From: Stuart Corbey
Sent: 29 May 2019 10:34
To: Lynnyrd Wolfe
Subject: FW: Worthing Road, Littlehampton - Planning application Ref: LU/59/19/PL
Attachments: LITTLEHAMPTON Watersmead Business Park - Drainage Strategy Report.pdf; DBN3-SMR-00-ZZ-DR-A-2009-S3-P1.pdf

From: Aarti O'Leary [REDACTED]
Sent: 23 May 2019 09:18
To: Laura Gibbons
Cc: Stuart Corbey; Serena Page
Subject: RE: Worthing Road, Littlehampton - Planning application Ref: LU/59/19/PL

From: Laura Gibbons [REDACTED]
Sent: 20 May 2019 13:45
To: Aarti O'Leary [REDACTED]
Cc: Stuart Corbey [REDACTED]
Subject: RE: Worthing Road, Littlehampton - Planning application Ref: LU/59/19/PL

## **Appendix E – Proposed Drainage Strategy**

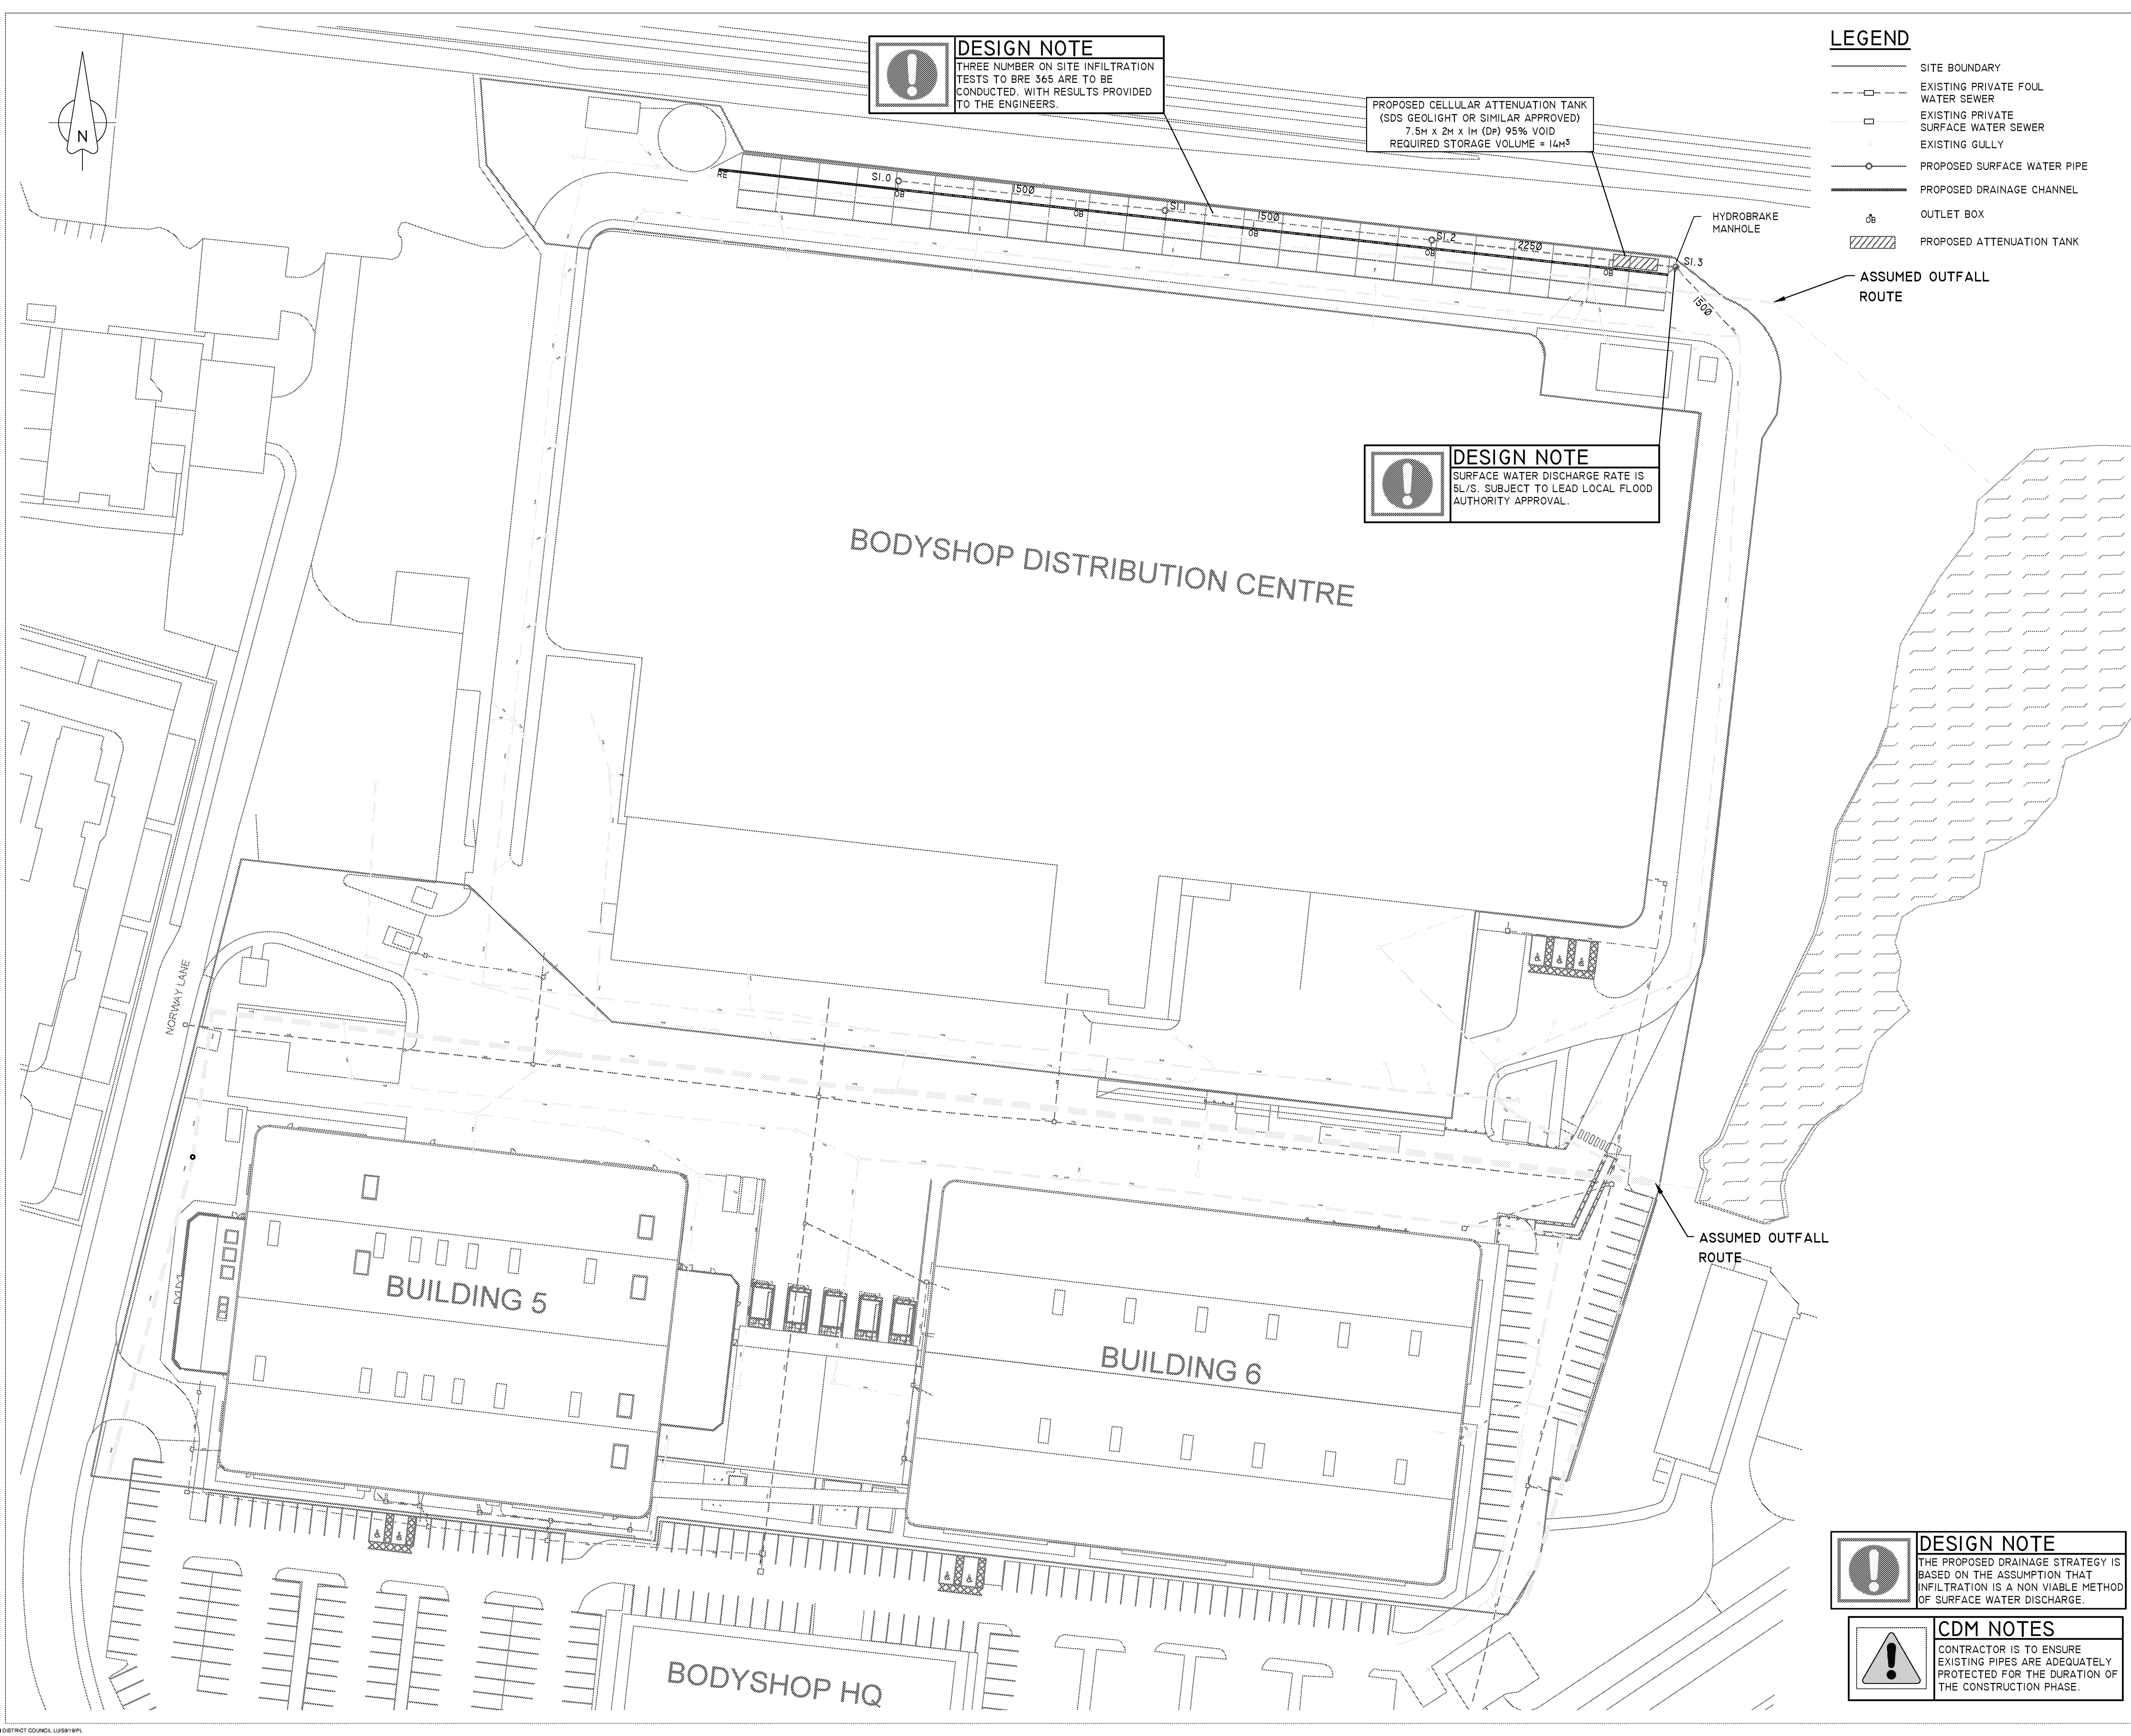
1. Worst case infiltration test results should be used in design, not an average.
2. What is the lifetime of the development, if it is over 40 years a 40% allowance for climate change should be utilised.
3. Safety factor of 4 is required, not 3.
4. Catchpits should be provided upstream of all connections to soakaways.
5. Please provide invert and cover levels on plan of inspection chambers/manholes.

Please find attached an updated Drainage Report that addresses the matters raised in your email of 20th May 2019.
